Planning Application: 23/02827/F

Heyford Park: Use of the Eastern Part of the Southern Taxiway and adjacent Hush House building for Car Processing Operations.

I wish to submit an objection to the above planning application

Figure 4.1 Proposed Vehicle Storage Areas

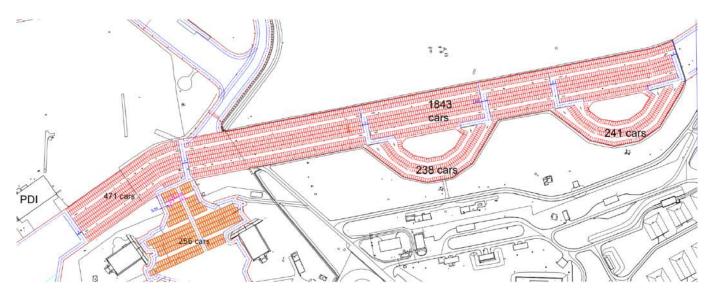
The January TA indicates a further intensification of use from 2,984 to 3,800 car spaces (still stating an impact of 24 transporter movements!) but fig. 4.1 in the April TA has 3,049 car spaces (65 more than the previous planning permission ref 18/02169/F). This change is not referred to and requires clarification.
